From: Craig Shinkin <Craig@wellandidb.org.uk>
Sent: 03 July 2026 11:48
To: Niland, Mark
Cc: _planningadvice; HighwaysSUDsSupport; Jane Picking
Subject: H14-0532-26 (CS/JP/P/P/3 - Full) - Land off Bervor Close, Pinchbeck, PE11 3ZN

Planning Application: H14-0532-26 (Full – Construction of BIO-LNG Refuelling Station)

Drawing Title: LNG DP STATION SITE/BLOCK AND LOCATION
PLANS
Scale: 1:250 and 1:2500
Date: MARCH 26
Drawn: DB
Checked: D

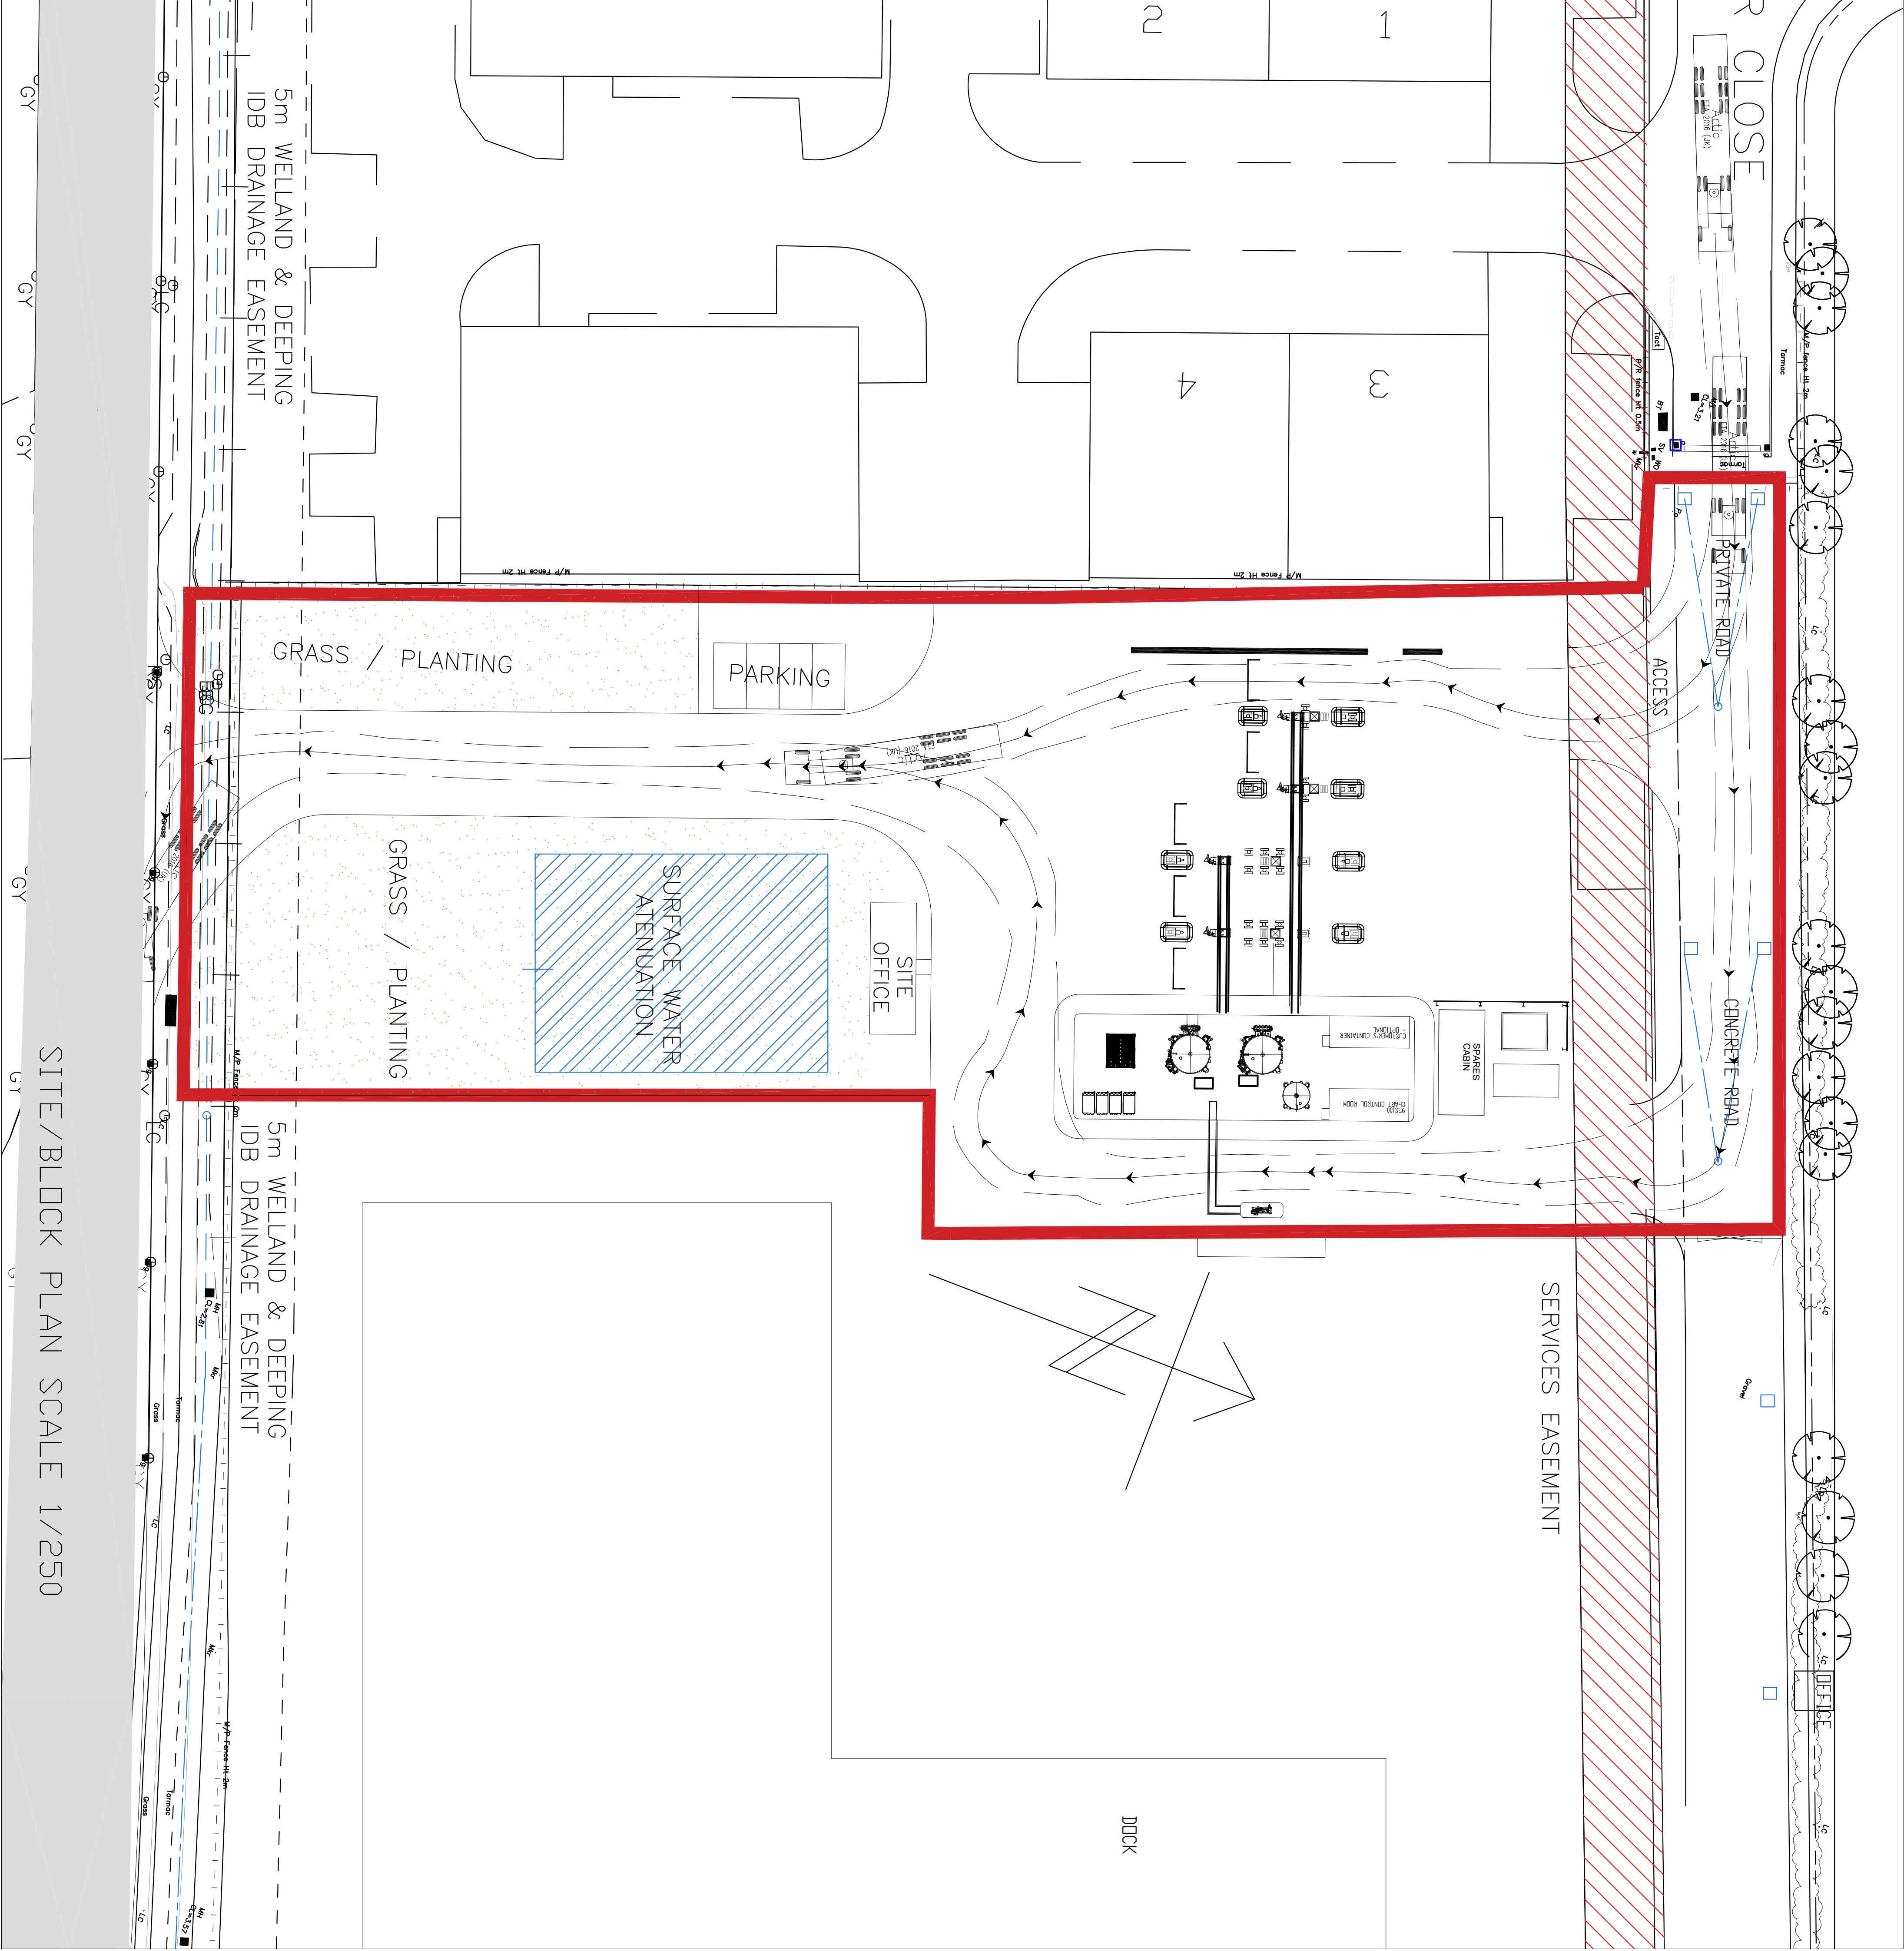
The Board's Wardentree Lane Dyke pipeline bounds the site along the south and is afforded the protection of a nine metre byelaw distance. This prevents anything new being placed within this distance without the prior written consent of the Board. Therefore, the proposed gate and fencing will require consent from the Board prior to works commencing on site and dimensioned plans should be provided to the Board clearly annotating proximity to the Board's asset.

As the Board's pipeline is being crossed over with a proposed new access, levelled survey drawings should also be provided to the Board detailing the difference in levels between the crown of the Board's pipeline and the closest material alteration crossing over it. This is particularly important given the nature of the heavy vehicles that will be accessing and egressing the site.

Drainage Plan

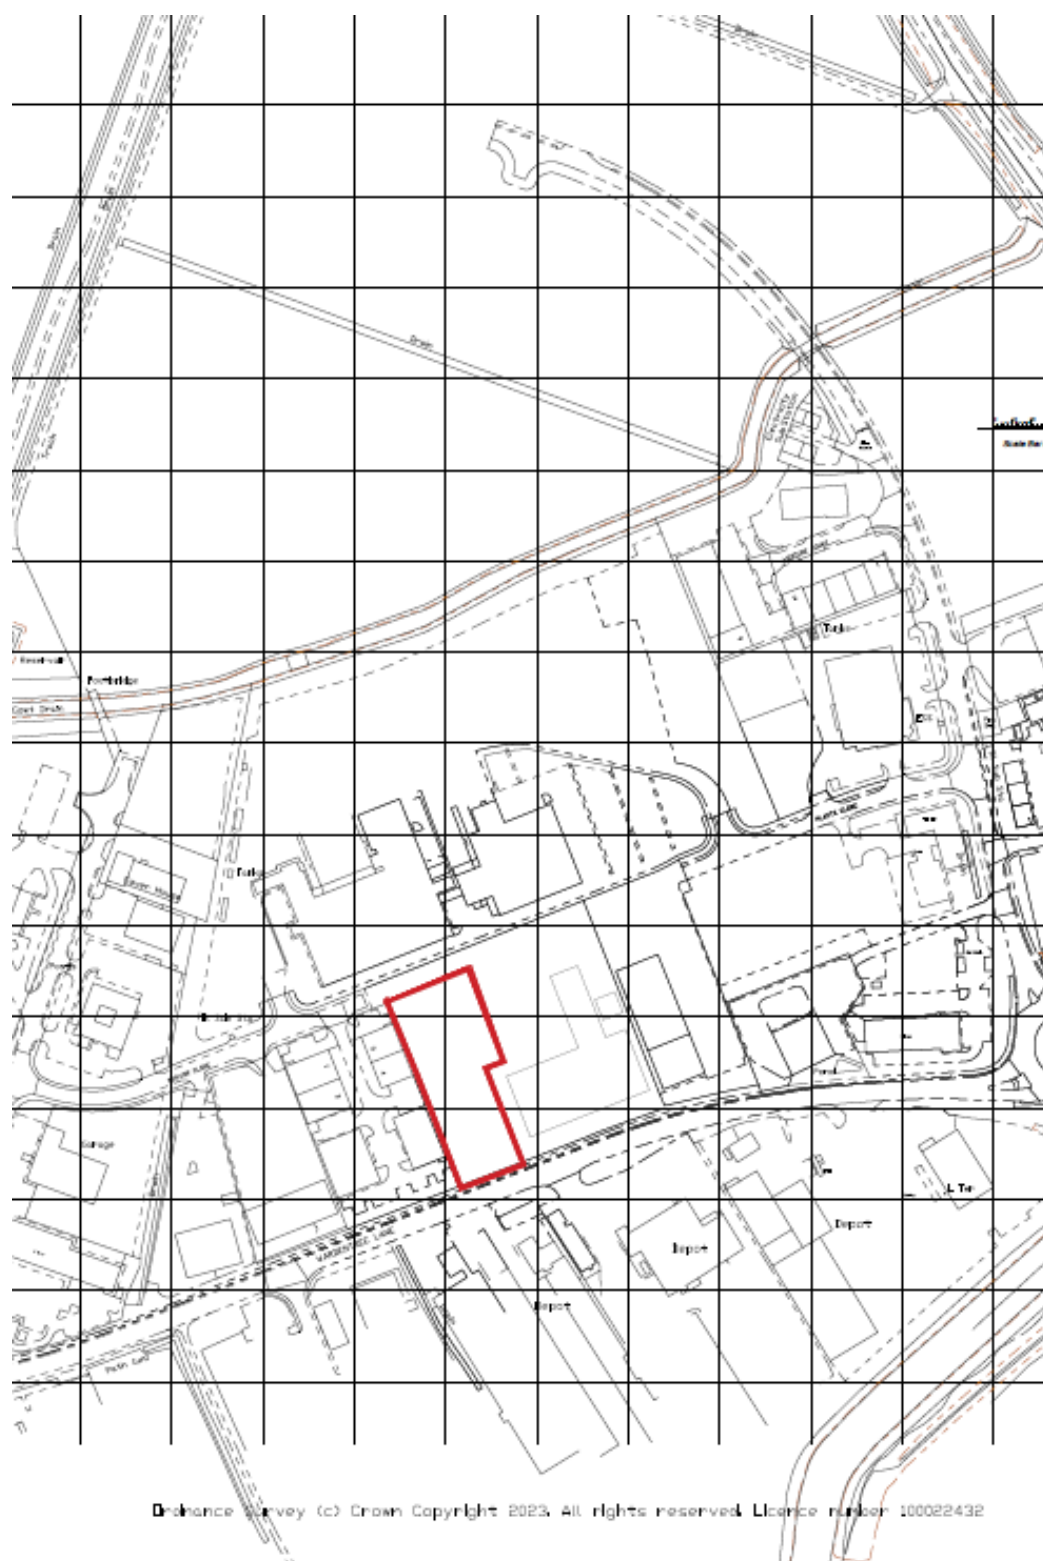
The proposed surface water discharge from the site requires the prior written consent of the Board should planning permission be granted. Any application is subject to the agreement of technical details, payment of the application fee as well as payment of the relevant development contribution. Based on a total impermeable area of 0.398 ha and a maximum flow restricted to 3 litres/second, this results in a development contribution of £10,073.30 payable in advance of connection. Please note that development contributions are subject to annual increase in line with RPI.
